**To:** Peter & Kathleen McAleney      **From:** Mike Nugent  
**Fax:** 874-2456      **Date:** August 6, 2002  
**Phone:** 775-1612      **Pages:** 1  
**Re:** 60 Portland Pier (030 B004)      **CC:**

I have left a message for Mike Hayes to call, I have some questions on the plans:

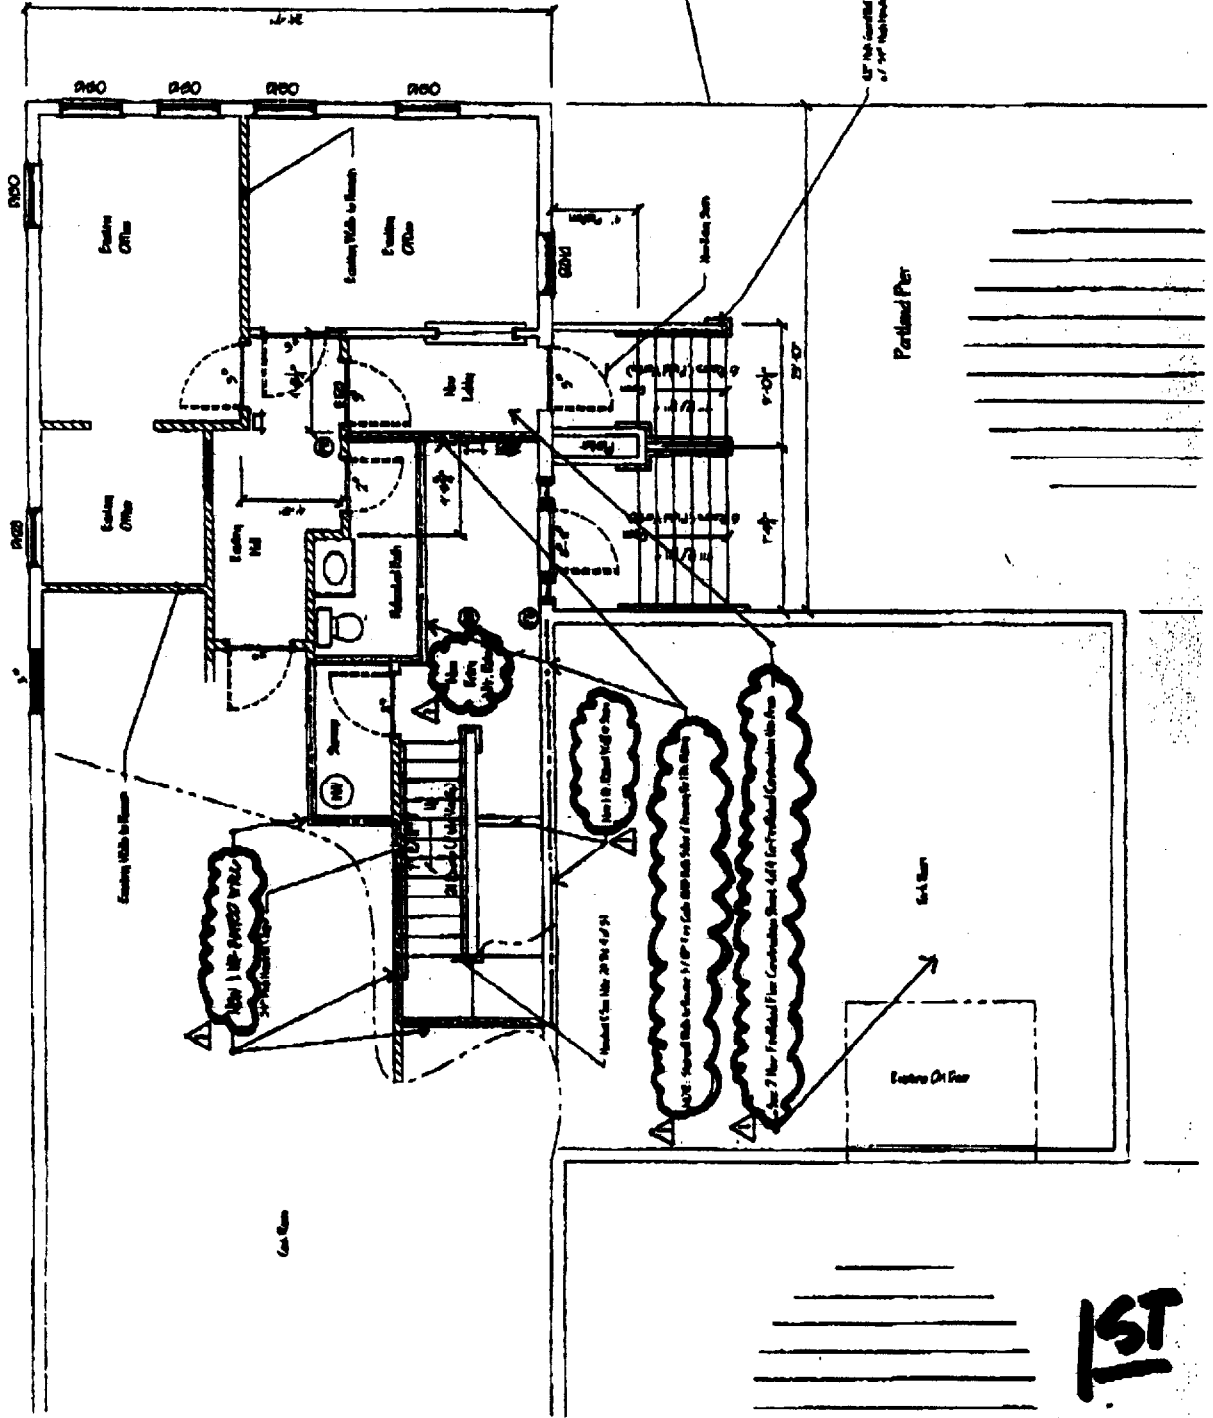
- 1) Floor and roof load of the Exterior Covered Deck
- 2) The 2 hr. fire separation on page 4 of 5 is "Similar to" UL L536, is it a 2 hr rating or not.
- 3) The floor plan does not show a fire separation between the office and residential use.
- 4) Are the windows specified for the sleeping room in compliance with egress standards.
- 5) Are there elevations available?
